Re: Marysville Corporate Center BSP – *Final Review 1*  
PA22004

After reviewing the application Final Binding Site Plan (BSP) application materials for the above referenced proposal, the following technical review comments are provided below.

**FINAL BSP Amendments**

INDEX DATA: SEC 28-33 T 31N R 5E WM
SURVEY FOR: PACIFIC REALTY ASSOCIATES, L.P. 15908 47TH AVE NE MARYSVILLE, WA 98271
SNOHOMISH COUNTY, WASHINGTON
SHEET 12 OF 13

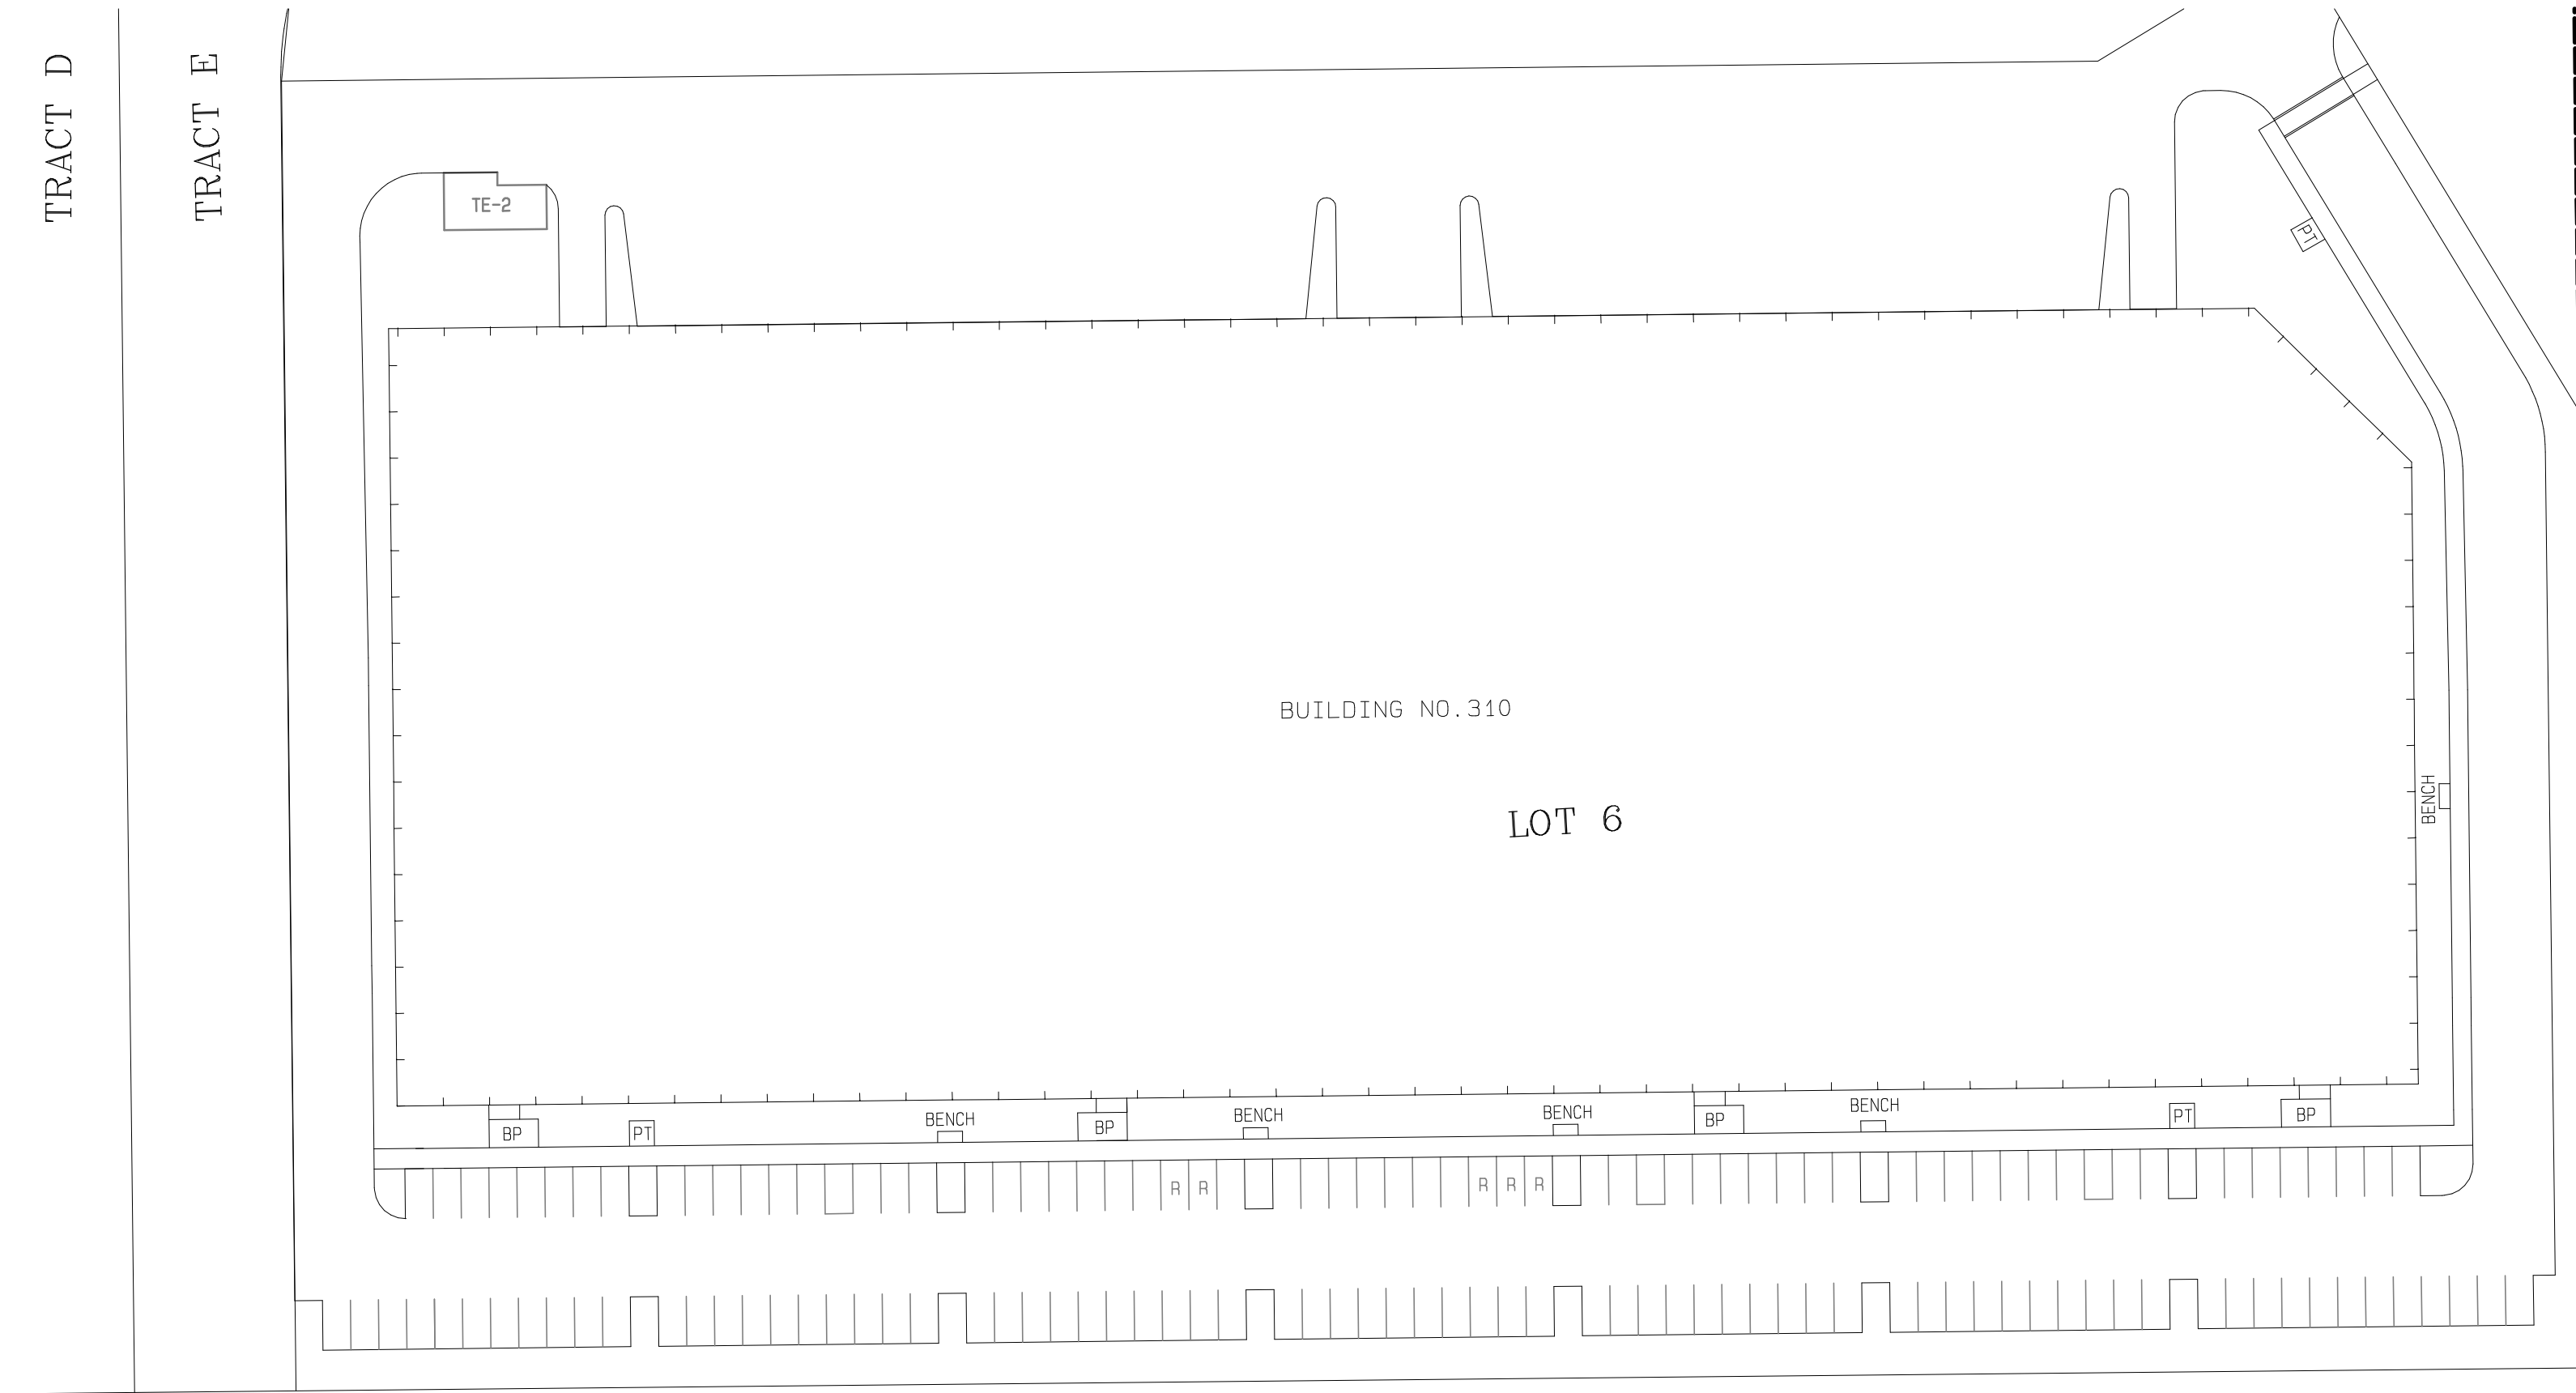
10. Sheet 11 of 13: Remove from FINAL BSP Set.
11. Sheet 12 of 13: Remove from FINAL BSP Set.
12. Sheet 13 of 13: Remove from FINAL BSP Set.
